National Highways Planning Response (NHPR 21-09) Formal Recommendation to an Application for Planning Permission

Council's Reference: 21/03267/OUT

Location: OS Parcel 0006, South East of Baynards House Adjoining A43, Baynards Green

National Highways Ref: 92857

BOUNDARY SECTIONS 11-15

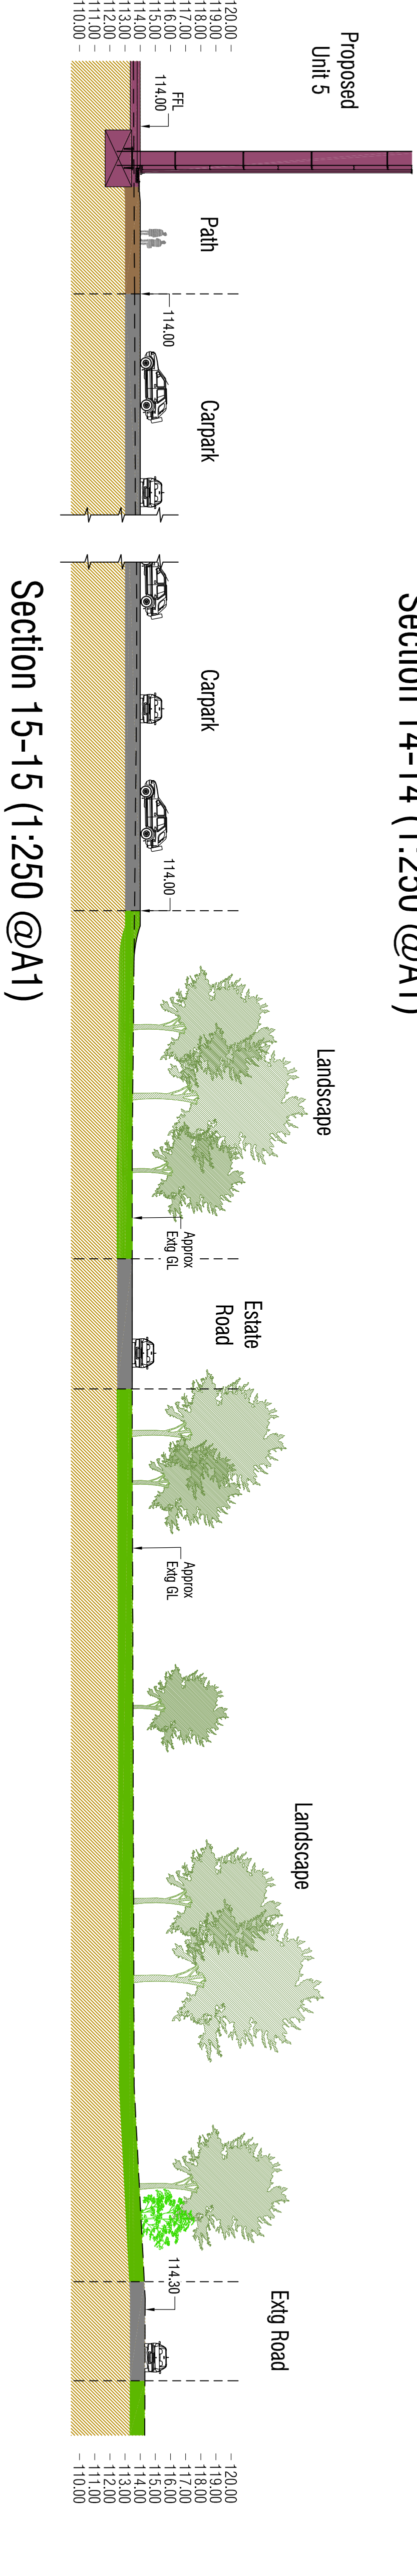
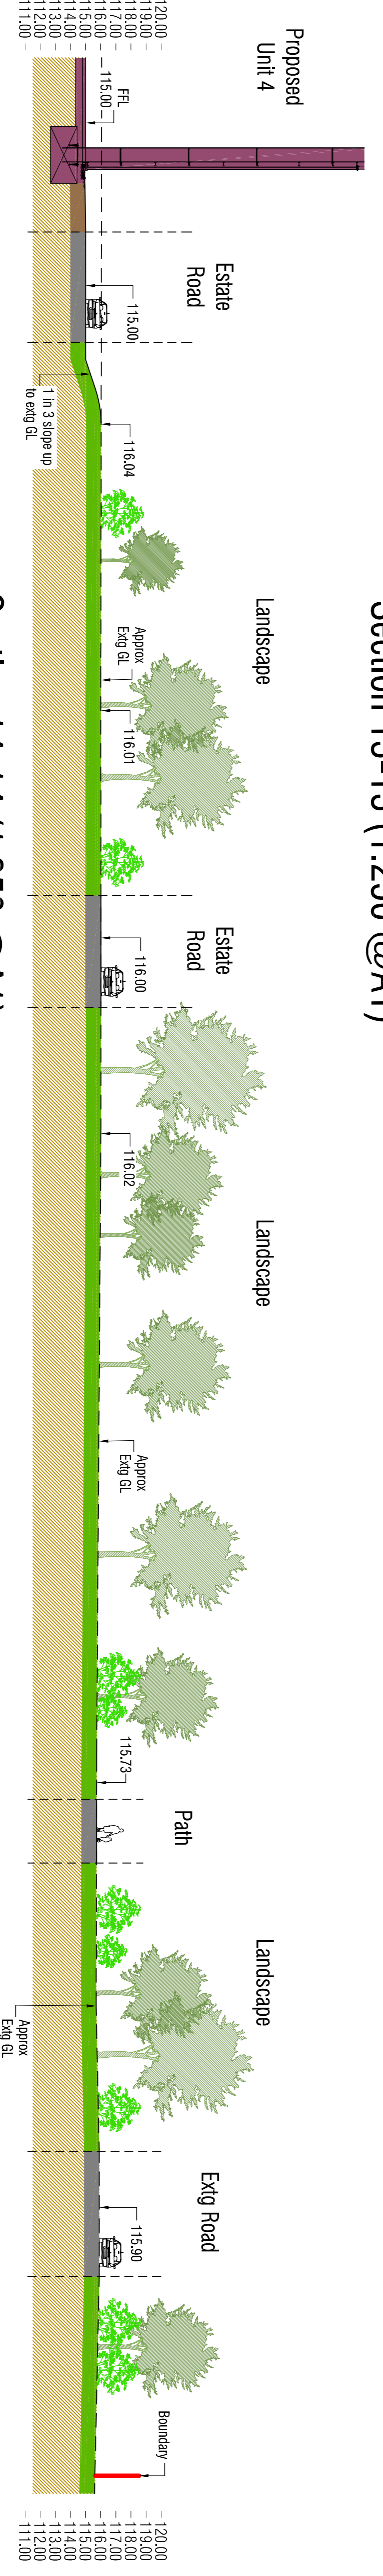
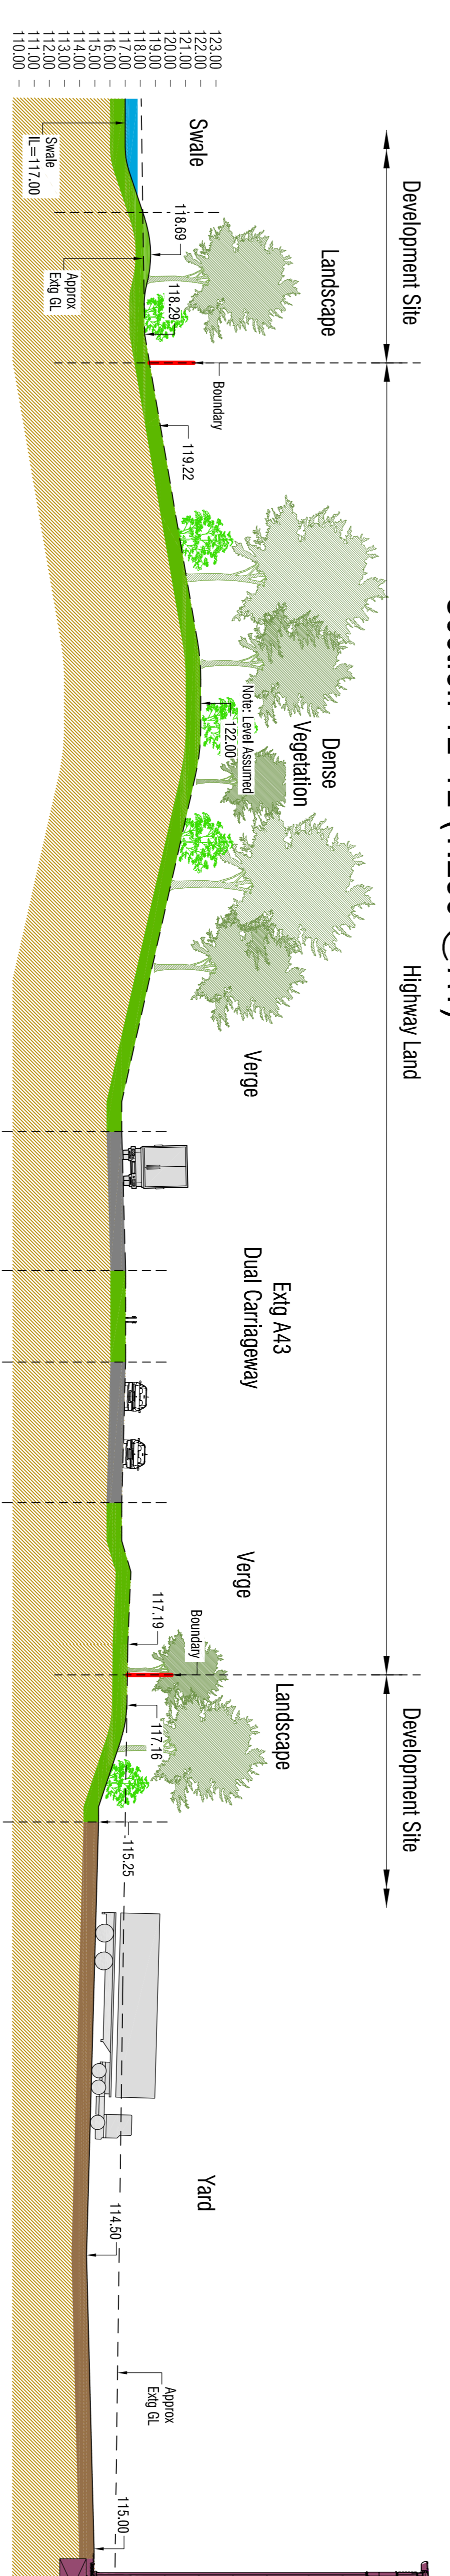
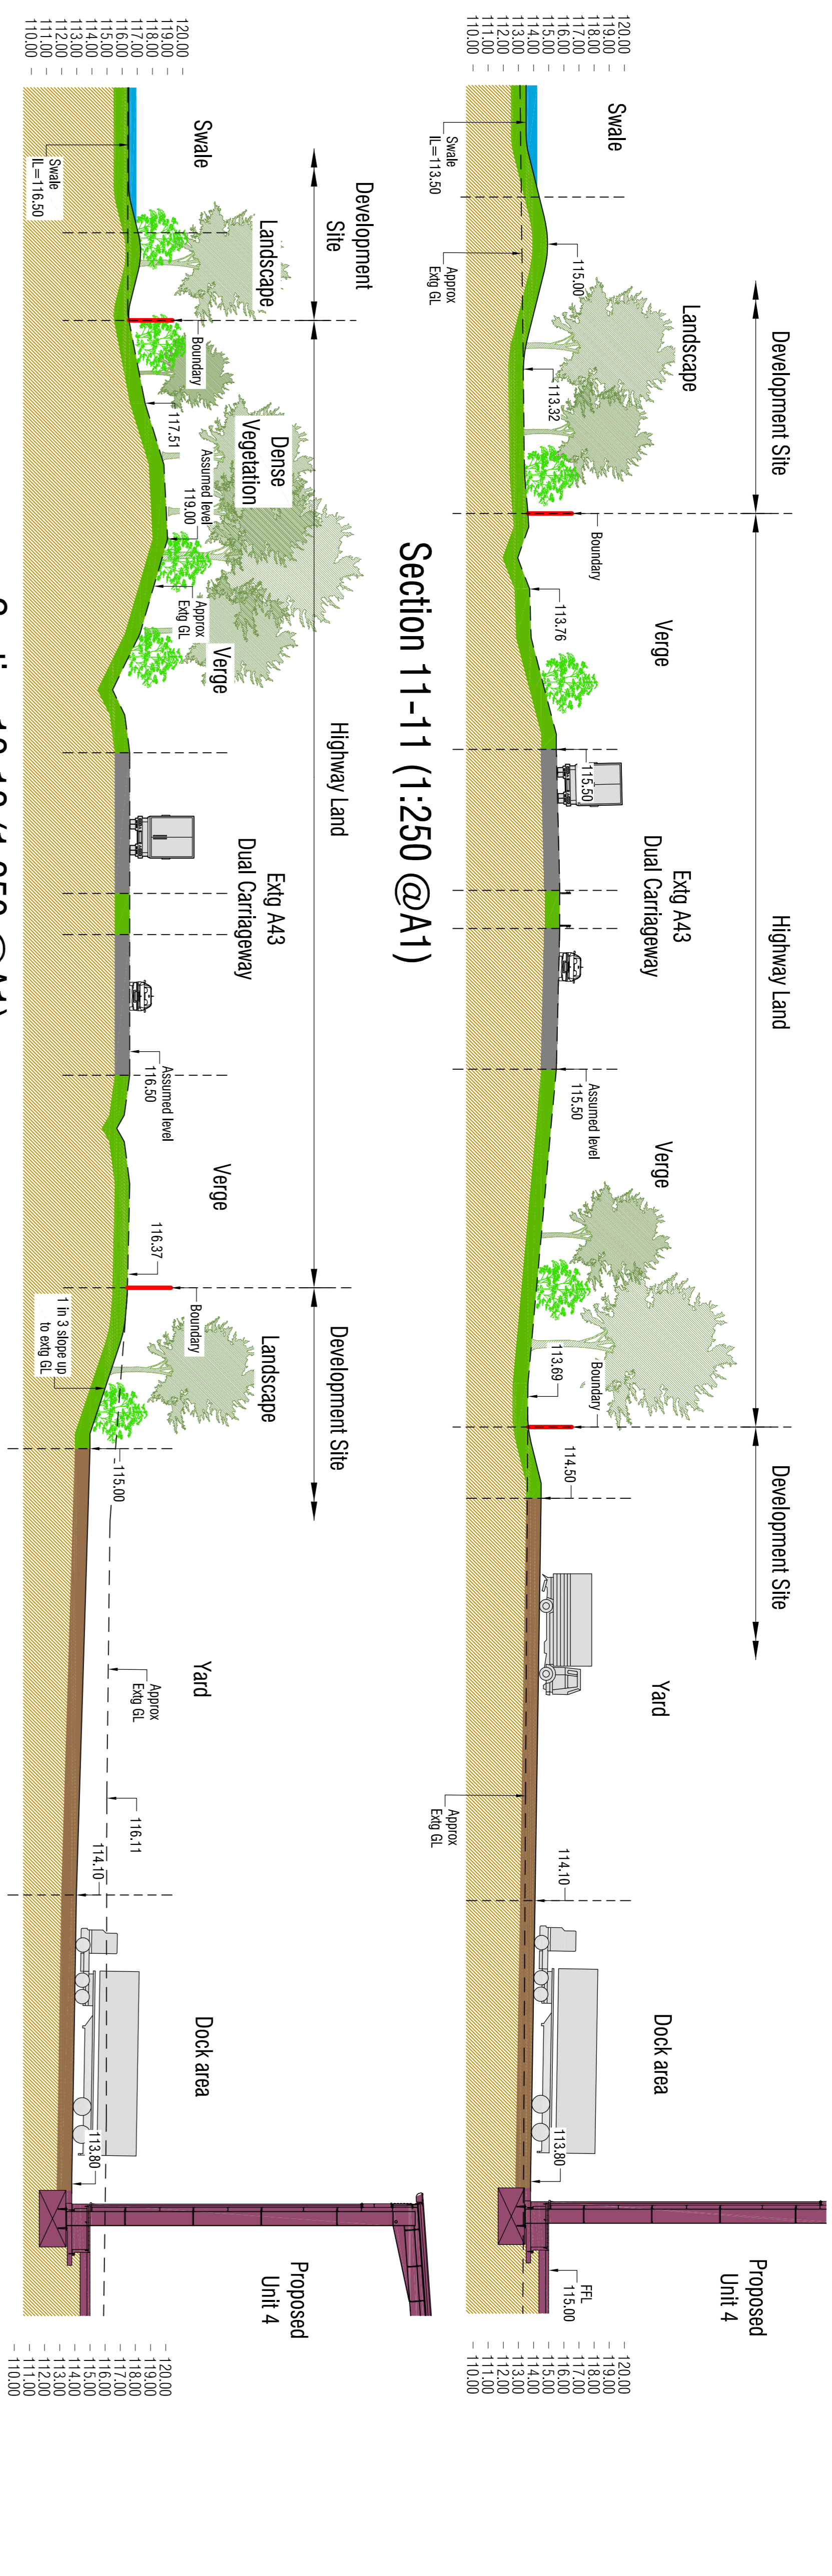
The applicant will need to advise / confirm if there will be any earthworks associated with the development(s) in relatively close proximity to National Highways boundaries (e.g. the stability of the balancing ponds, etc). In the first instance, some cross sections (to scale) through the boundaries showing the proposed extent of the development, its features and any proposed changes in elevation (excavations, landscaping) etc should be submitted for further assessment. Once received, we will review to determine the possible extent of any geotechnical reporting under the Design Manual for Roads and Bridges (DMRB) standard CD 622, which may be required to confirm the extent of any geotechnical risk to the SRN.

JOB TITLE		M40 JUNCTION 10		CLIENT		ALBION LAND	
DRAWING TITLE							
EASTERN ACCESS GENERAL ARRANGEMENT PRE-GROWTH FUND SCHEME							
SCALE	DRAWN BY	DATE	DRAWING No	REVISION			
1:500@A1	RM	03/08/21	17213-16-GA	P0

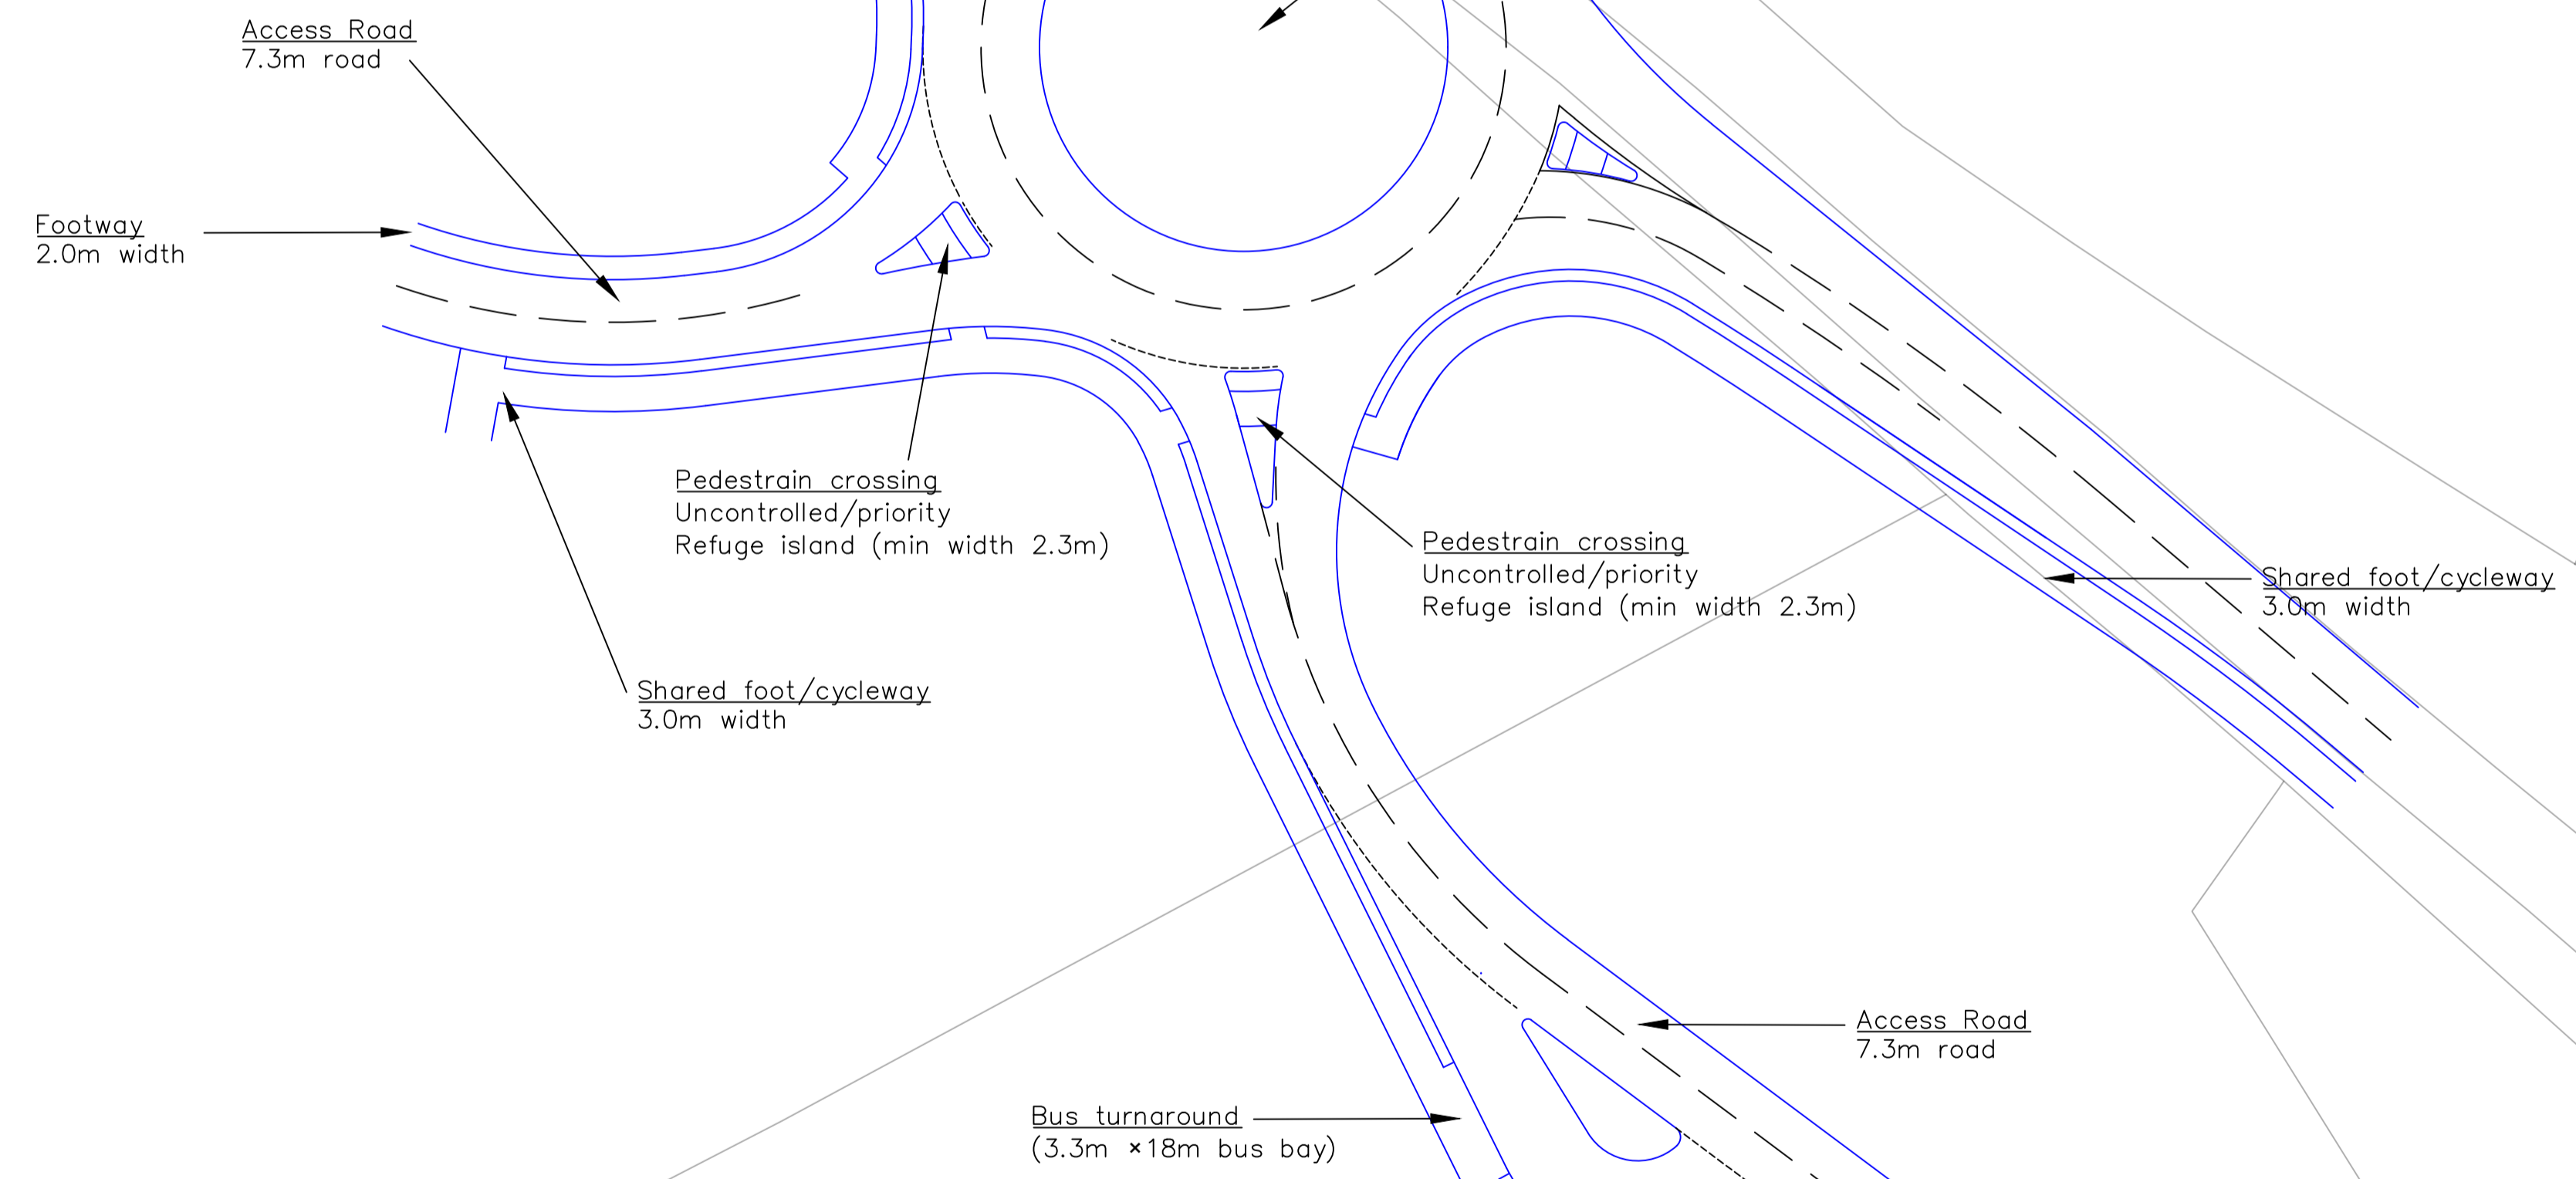
The applicant has proposed an interim mitigation scheme at the A43 Baynards Green roundabout which includes widening of the B4100 entries and a standalone signal-controlled toucan (pedestrian and cycle) crossing.

As there remain outstanding concerns, and the proposed improvement scheme as part of the Growth Deal scheme at the A43 Baynards Green roundabout and M40 J10 has not been modelled into the assessments, it was stated in our previous response that National Highways is not in a position to comment on the suitability of the interim mitigation scheme.
